File No: MP11_0093 MOD 1
Our Ref: R/2018/17

RE: Pemulwuy, MP11_0093 MOD1

Thank you for your correspondence dated 13 July 2018 which invites the City of Sydney ("the City") to review the application to modify the project approval as follows:

Plan Level 02- Townhouses
Plan Level 01(GF) - Mixed Use Building

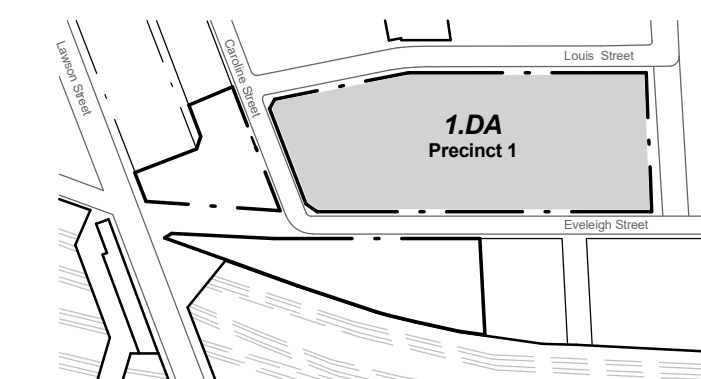
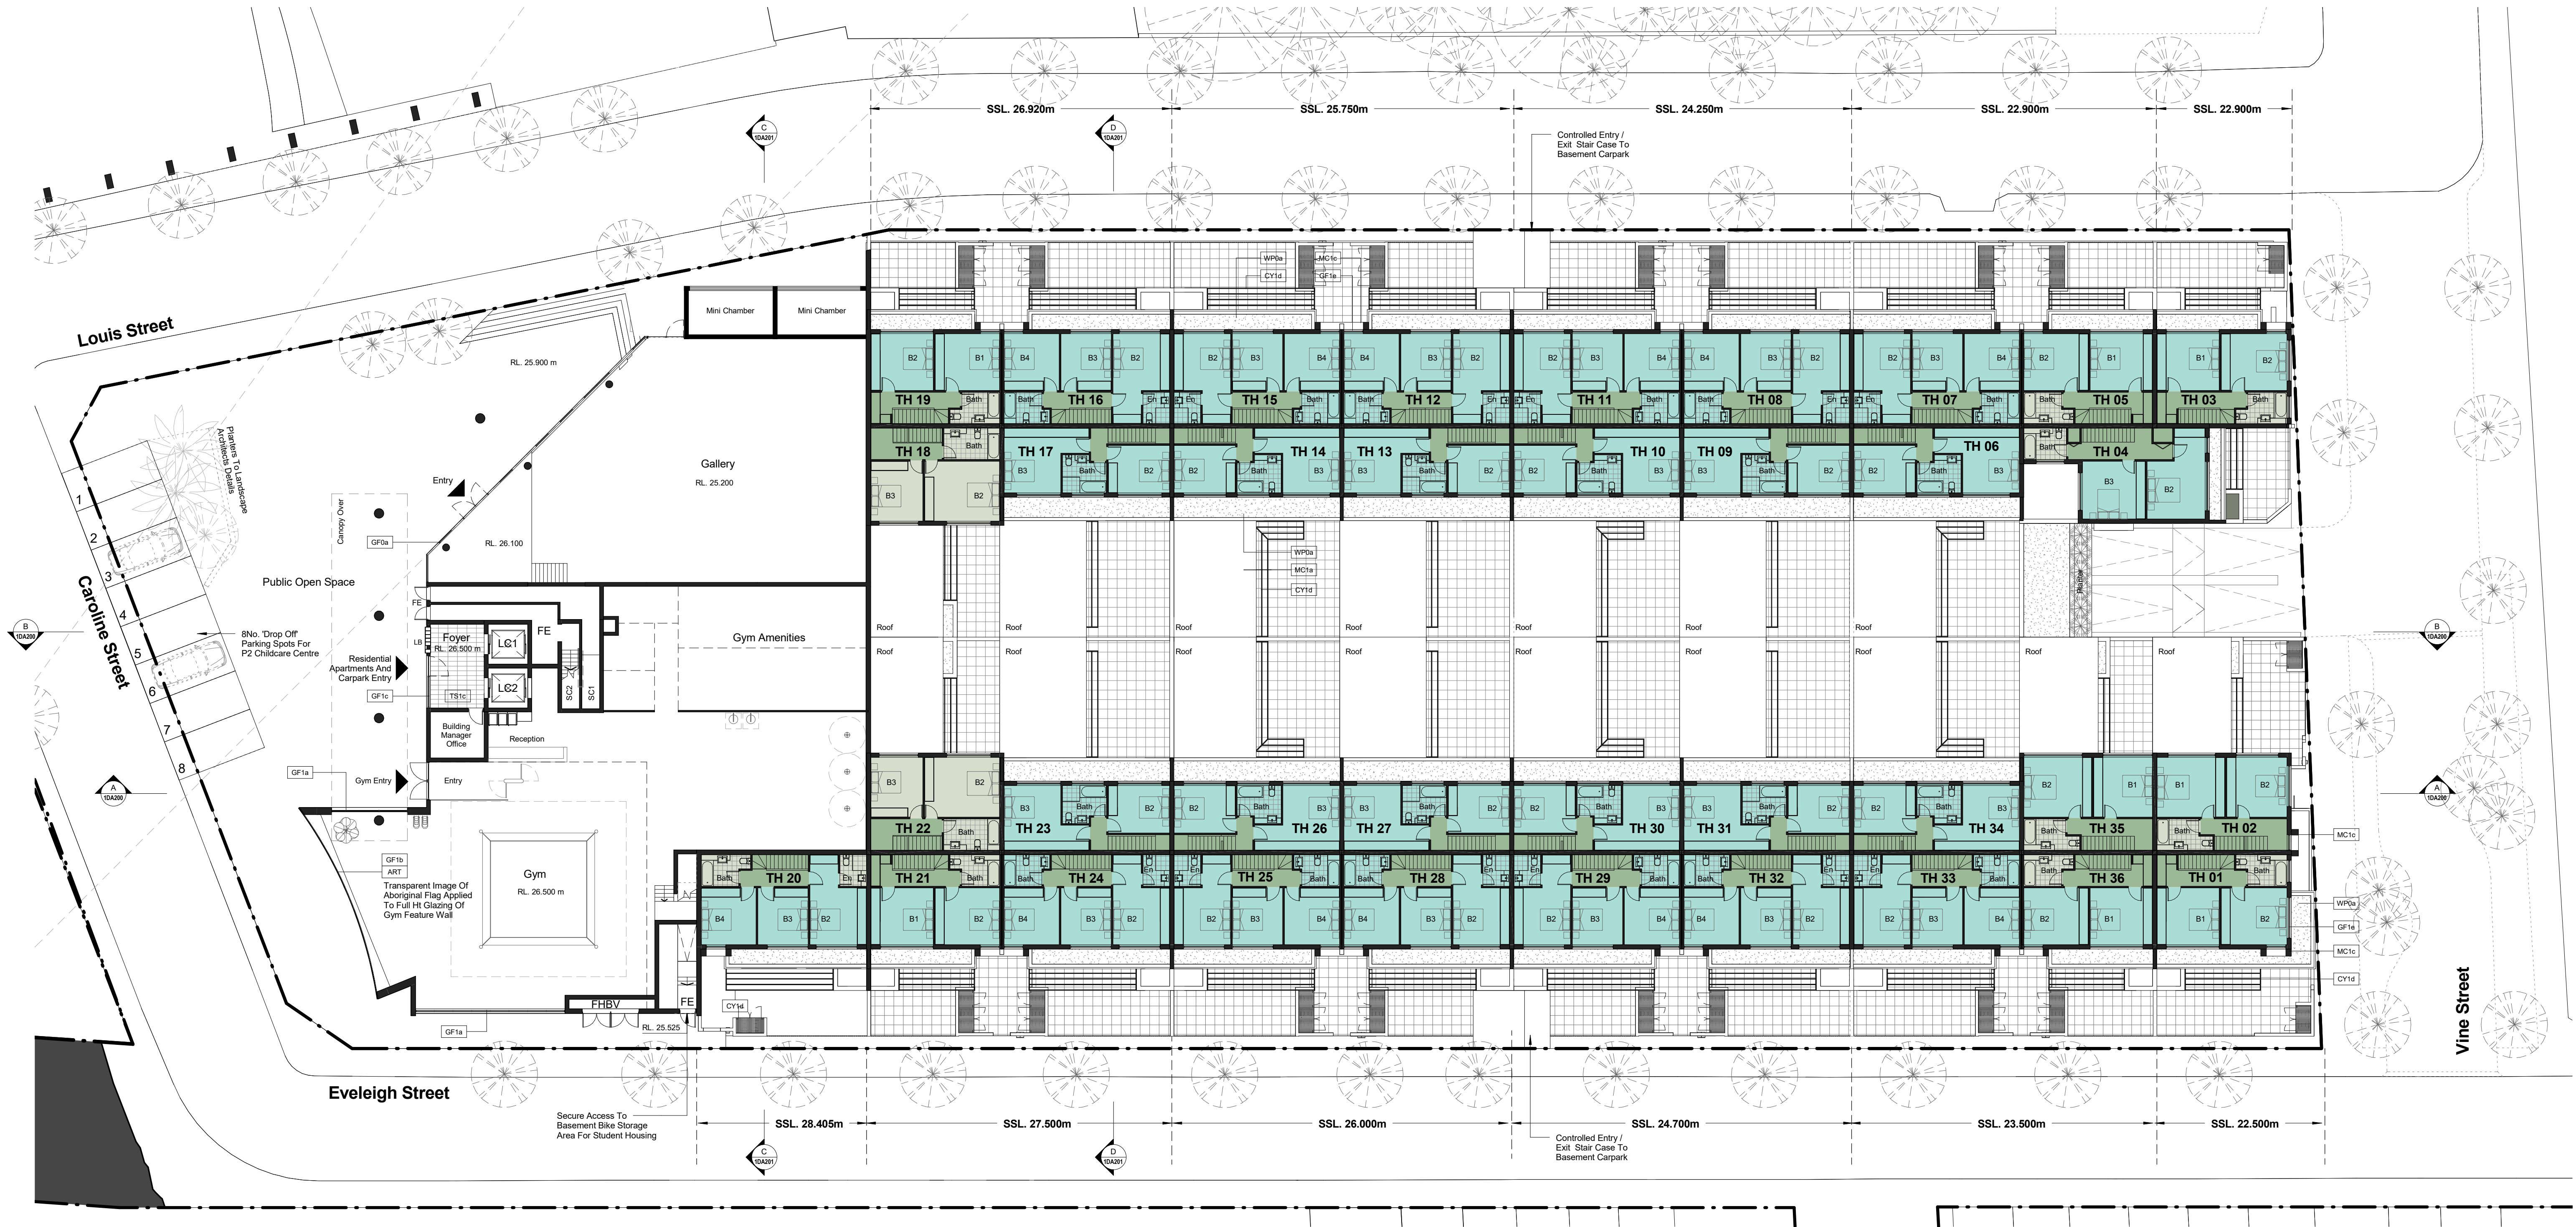
- The City supports the formalisation of locating the gallery space to a specific precinct, given its removal from the Precinct 3 SSD proposal which is currently under assessment. However, without a specifically identifiable physical space shown on proposed/approved plans, the City has concerns in terms of ensuring the provision and ongoing existence of the gallery space. This application would be the opportunity to provide a plan for the space and ongoing assurances in terms of its ongoing existence, rather than modifying the project approval description as proposed.

- The Deed between the Aboriginal Housing Company (AHC) and the City requires the provision of the gallery space as a core element.
- The size of the gallery space should be confirmed in the application and be as close as practicable to the previous approval (485m²).

Proposed Site Plan - Precincts 1 and 2

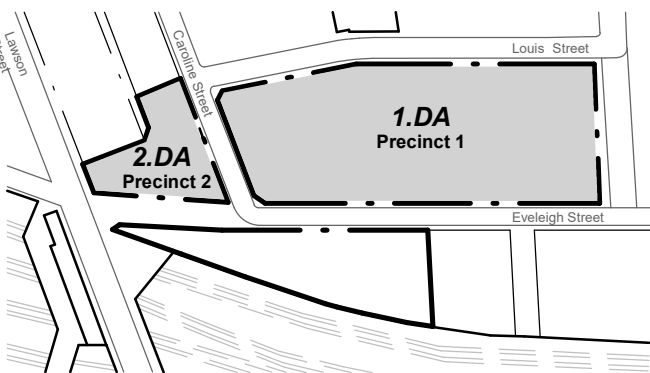
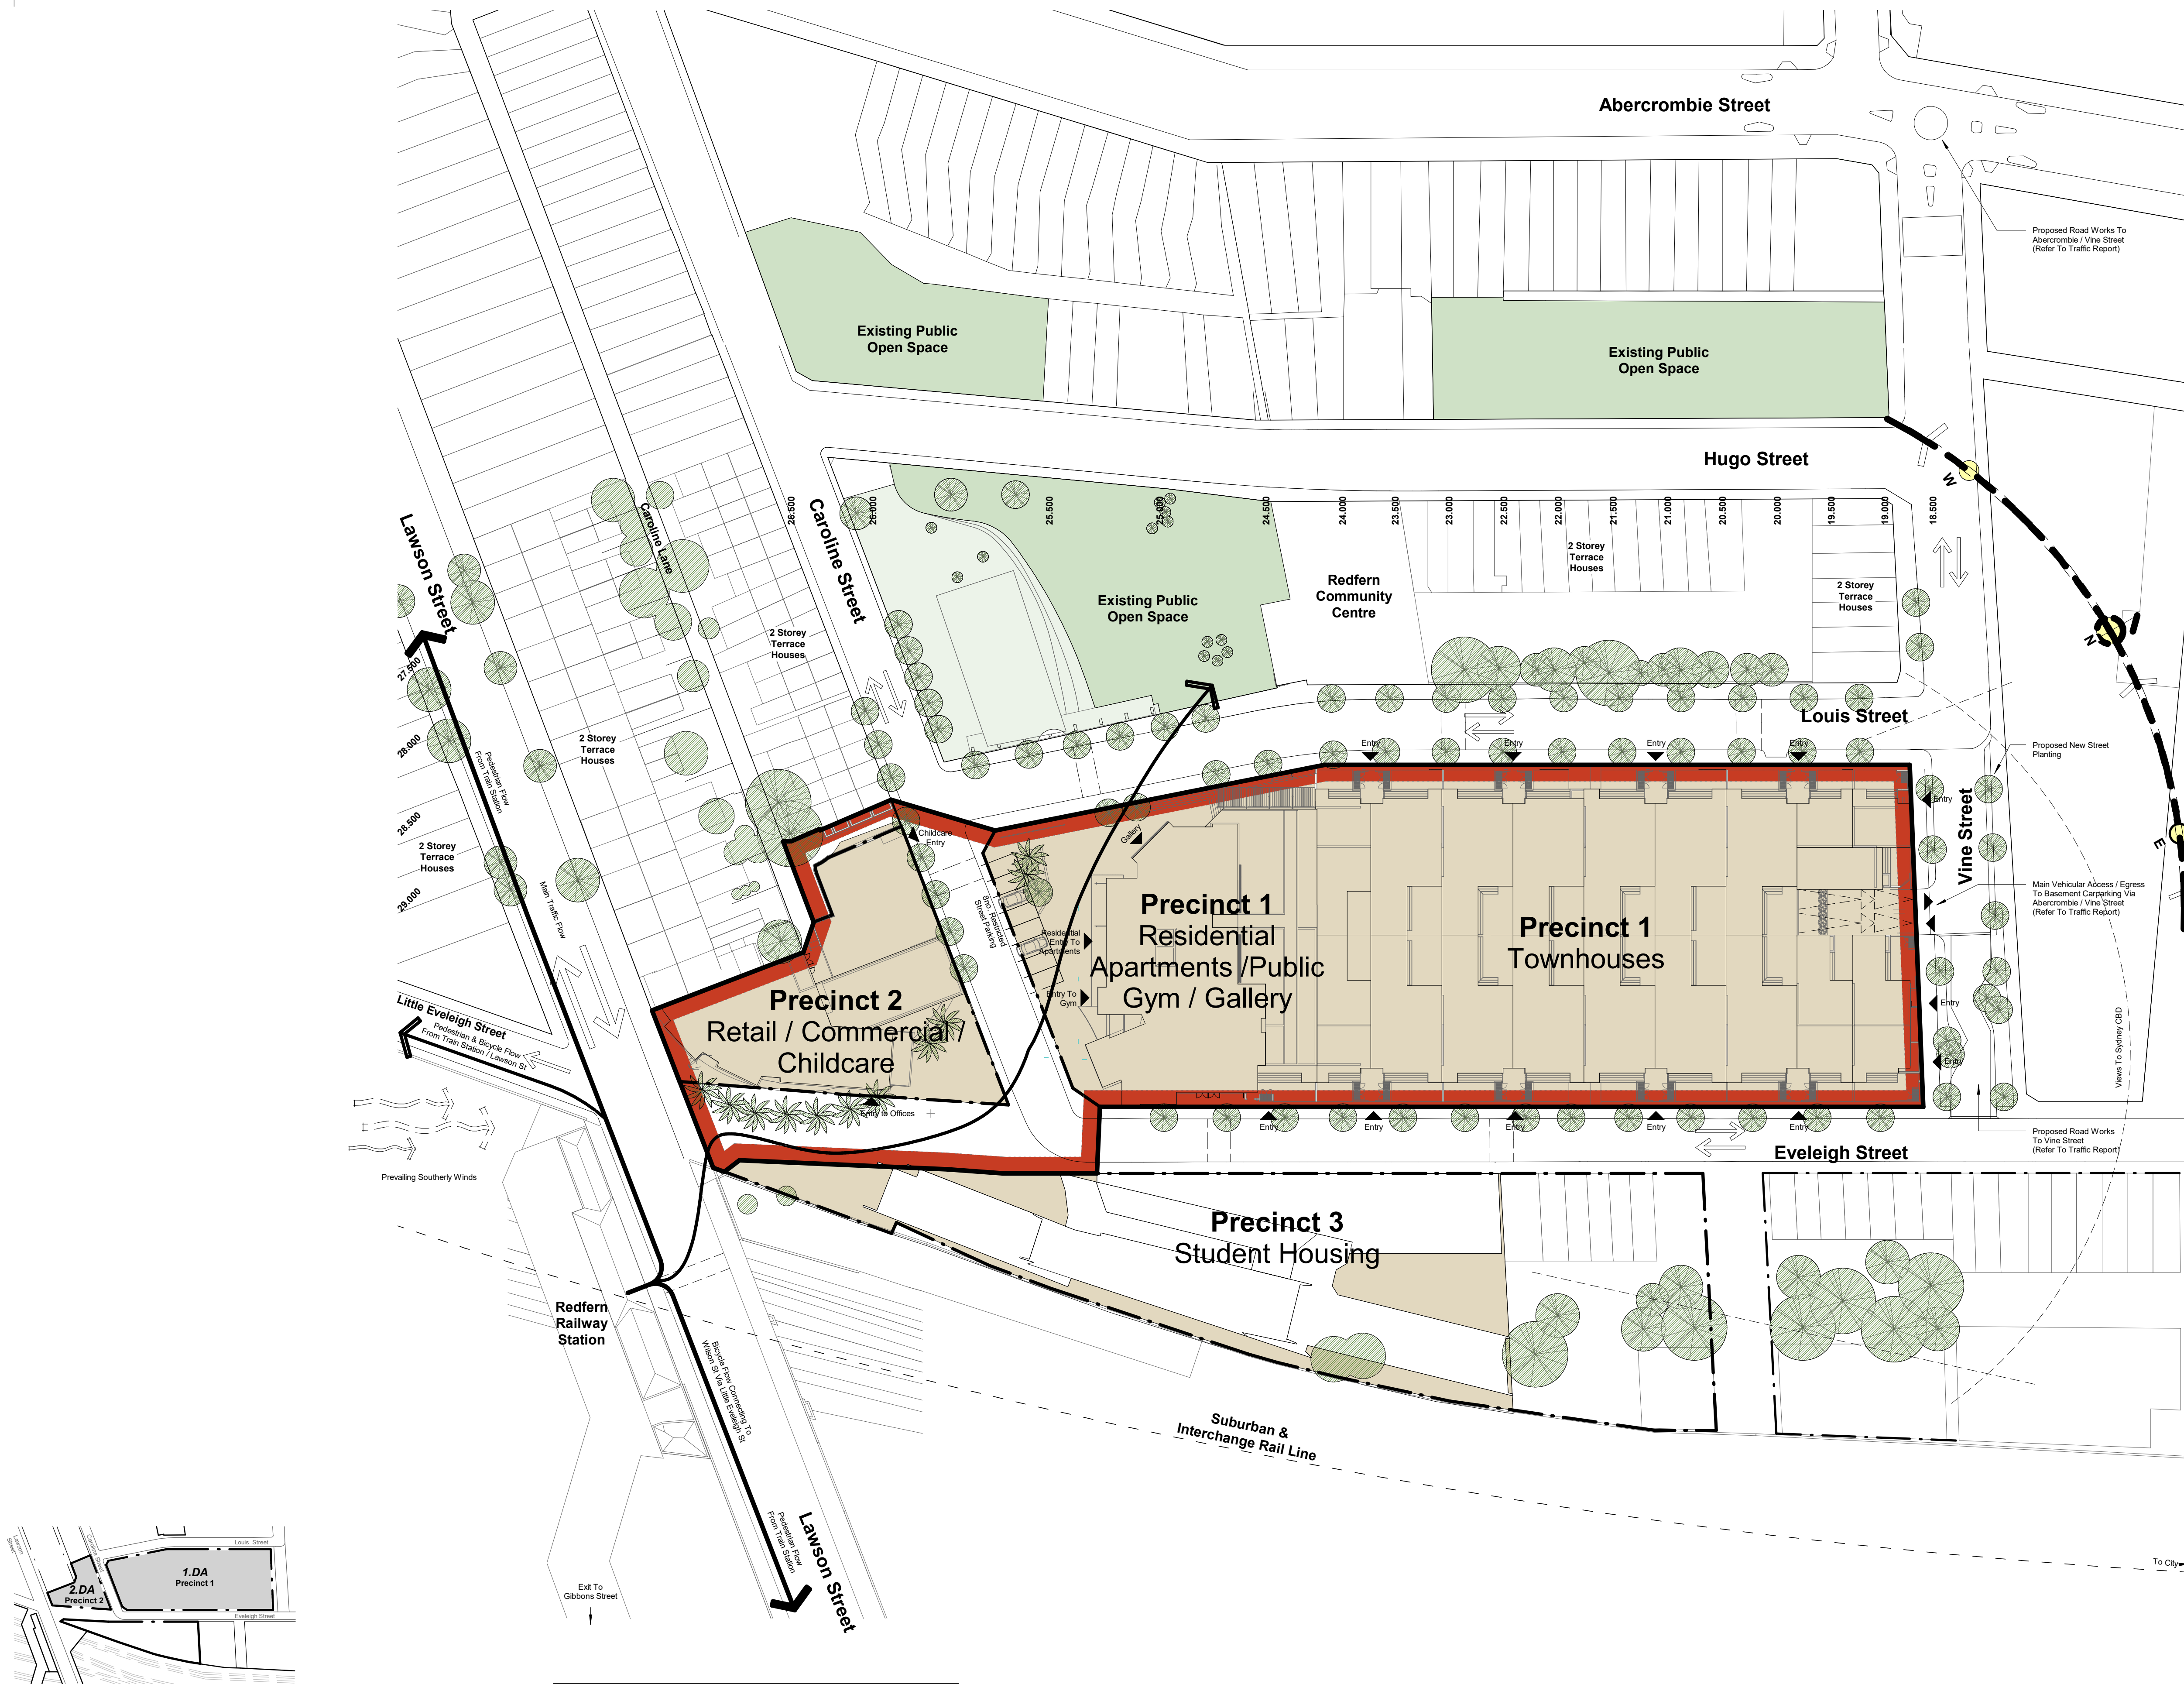
- The provision for a future land bridge over the railway corridor should be investigated with discussions with Transport for NSW.
